From: Simon Davis
Sent: 15 April 2019 15:02
To: Planning.Responses
Subject: FW: BR/311/18/PL University of Chichester - Updated FRA
Attachments: 151933_STL_00_ZZ_DR_A_ZZZZ_V0003.pdf

SUITABILITY STATUS	SCALE
PL : PLANNING	@ A1
PROJECT ORIGINATOR ZONE LEVEL TYPE ROLE CLASSIFICATION NUMBER	REVISION
151933-STL-00-ZZ-DR-A-ZZZZ-V0003	P01

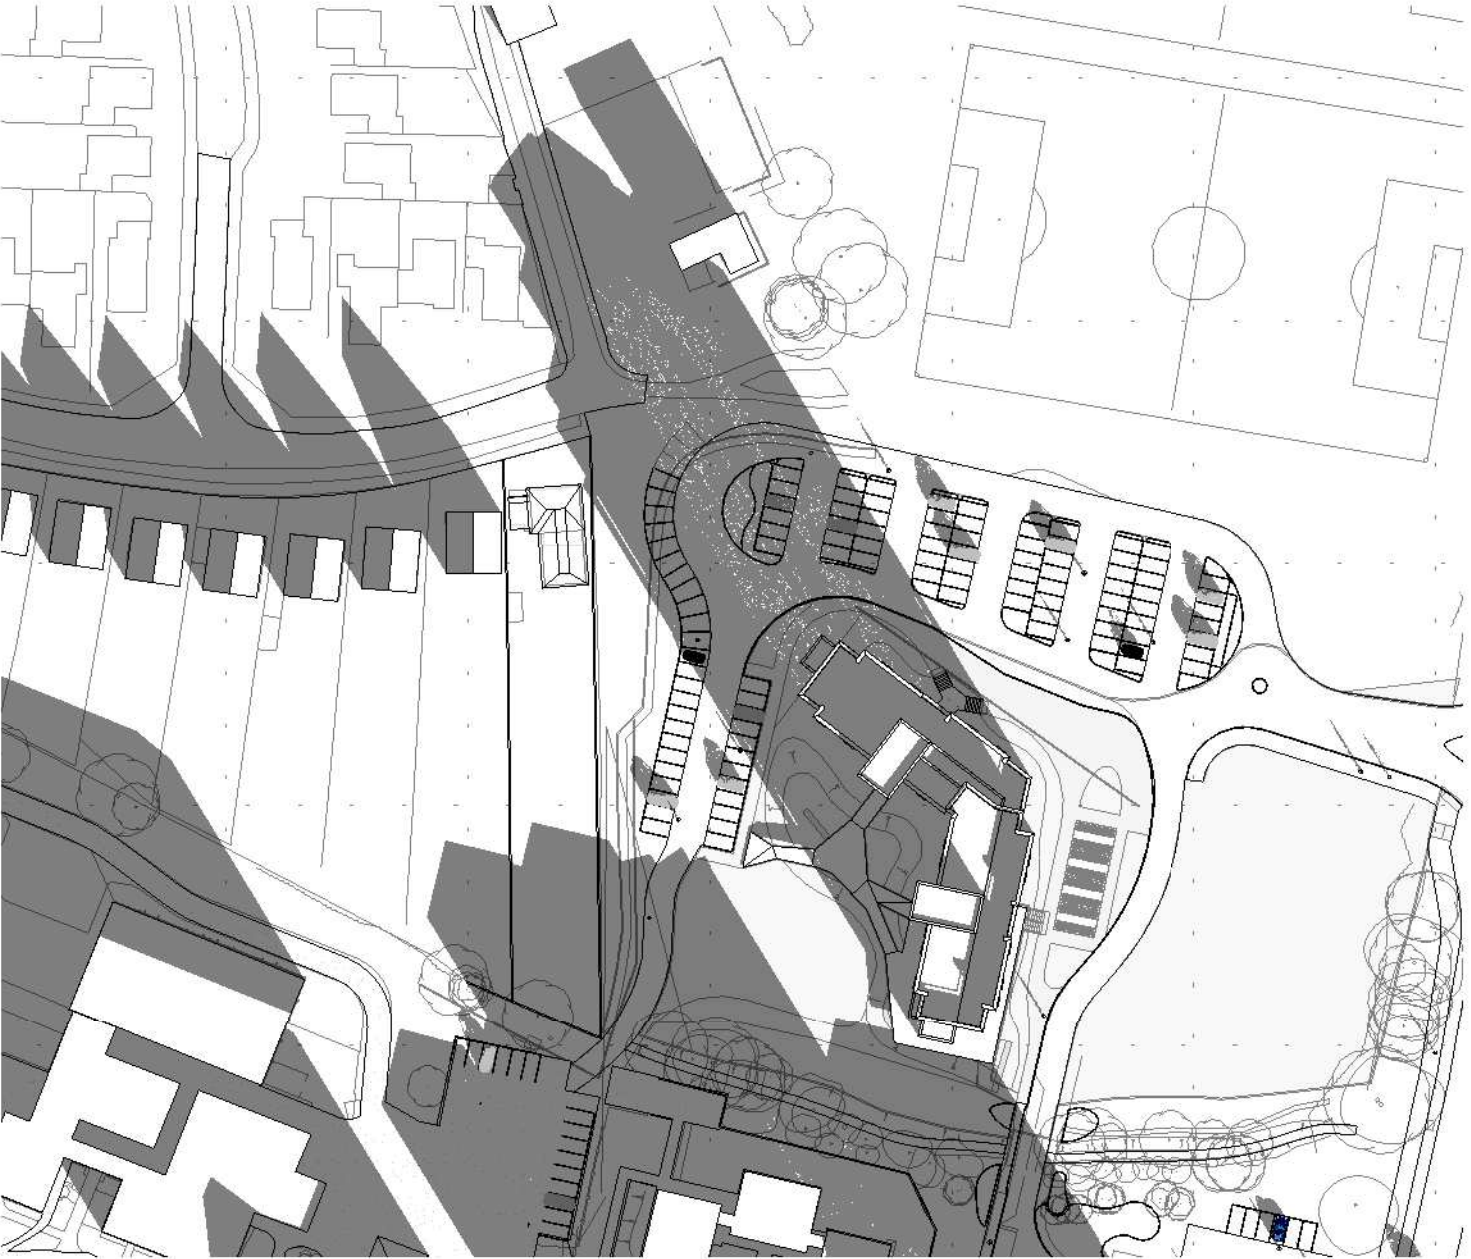
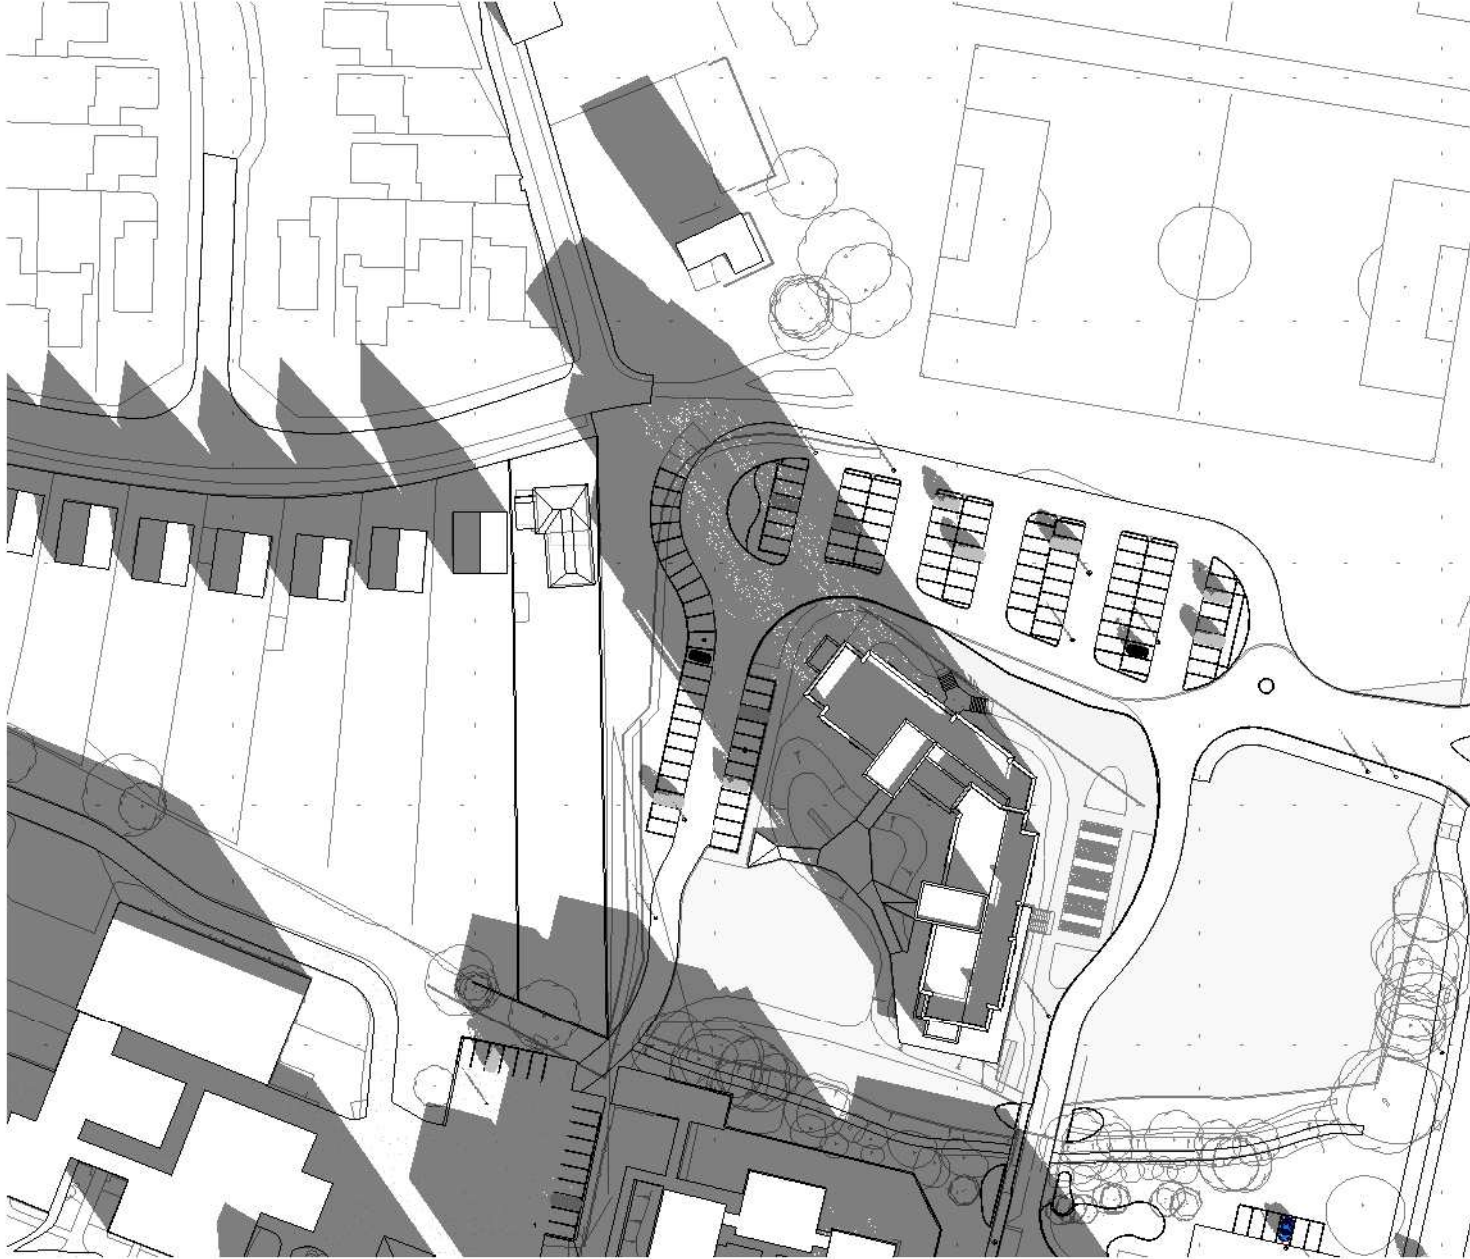
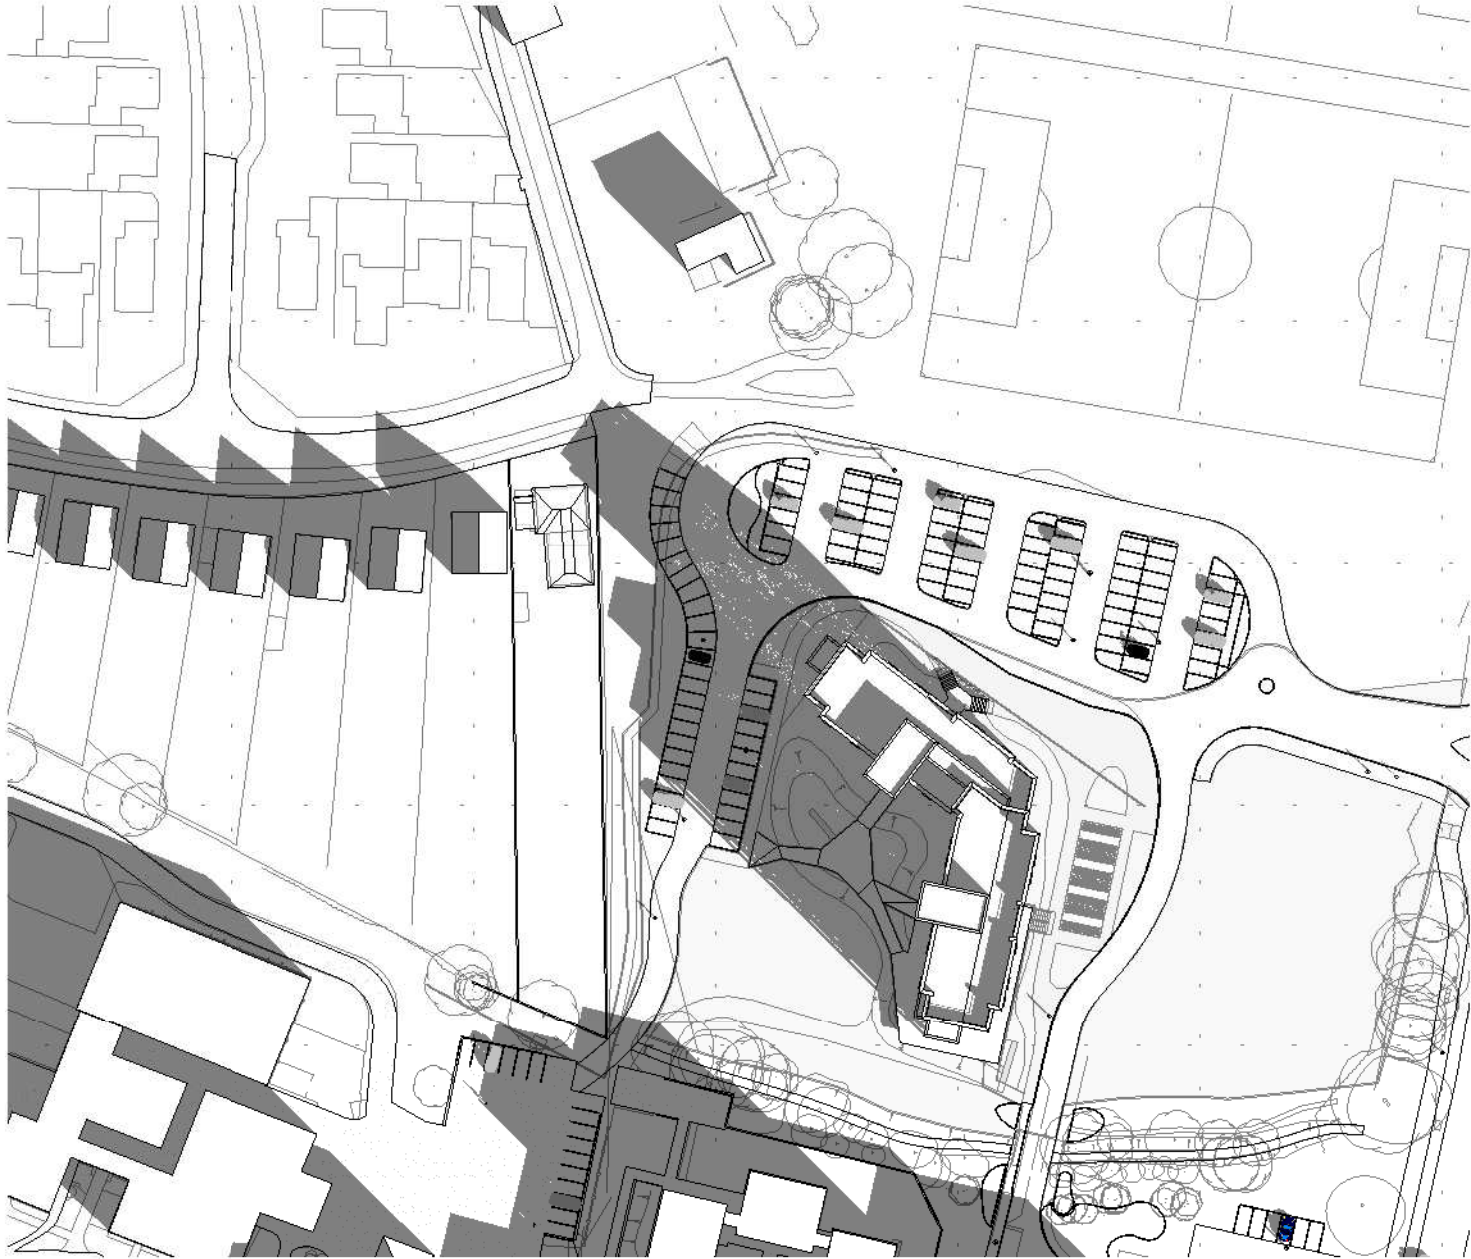
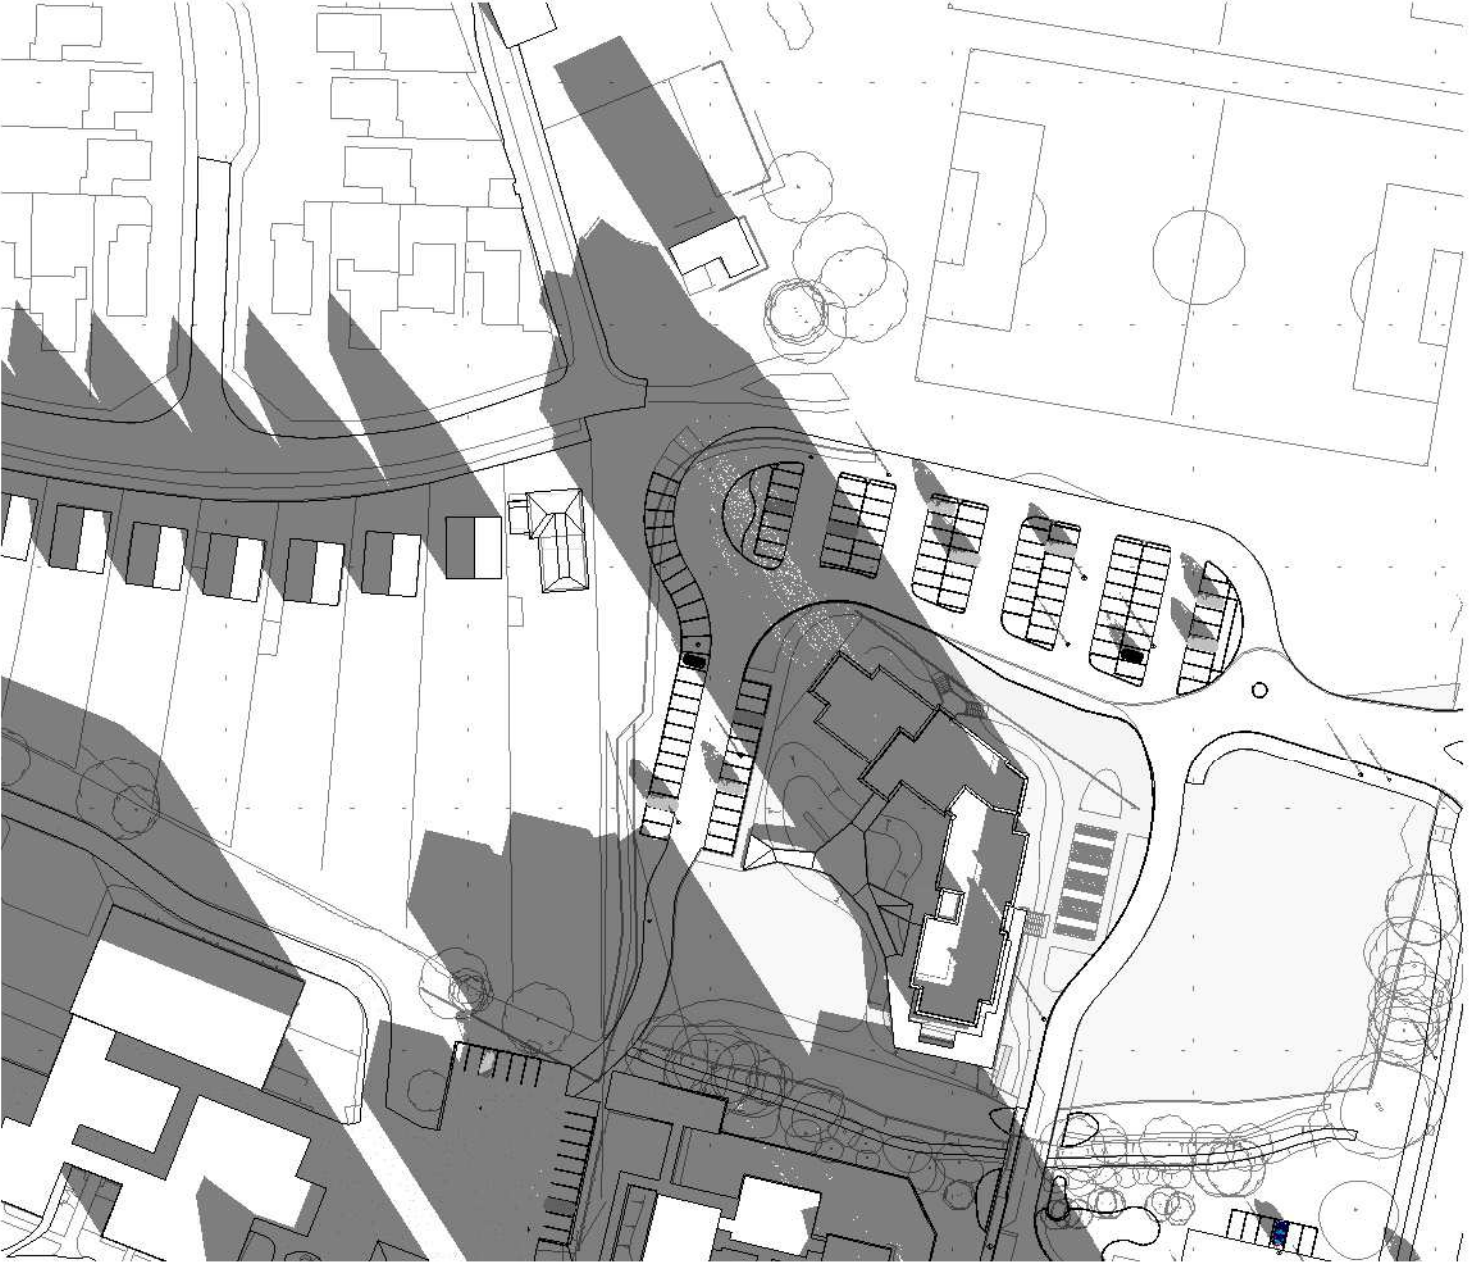
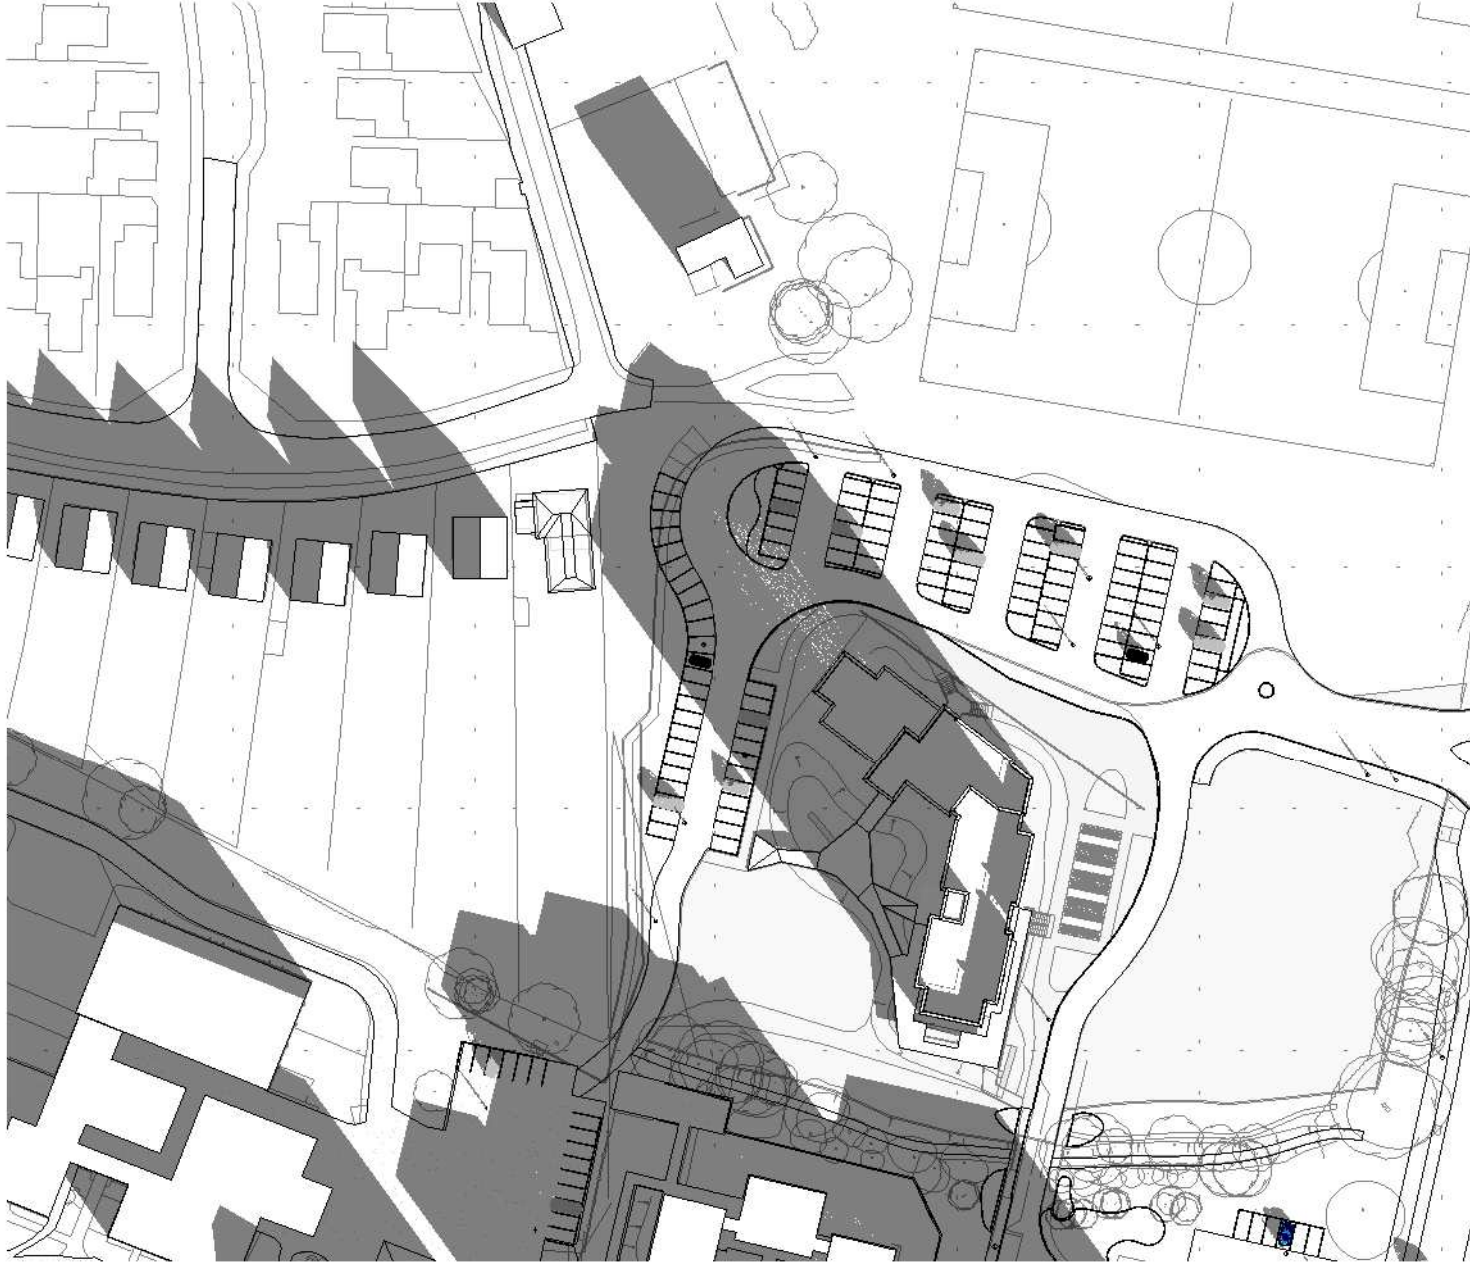
I also spoke with our Director earlier this week. He wanted to know whether the shading analysis assesses the impact during the winter on the bungalows to the west. I can see that the shadow study does give shading for 10am, 12 and 5pm on January 20th. However, it doesn't quantify for how much of the day the bungalow/its garden will be in shade. Would it be possible to provide this?

As requested, please find attached a further shadow study which shows the time at which the adjacent bungalow are out of shadow in the winter months for the approved and proposed scheme.

The study highlights the minor differences in the extent of shadowing at a time of year where the impact of any shadowing would be greater due to the shorter days. The difference between the approved and proposed scheme is between 5-19 minutes which is not considered to have a significant negative impact upon residential amenity.
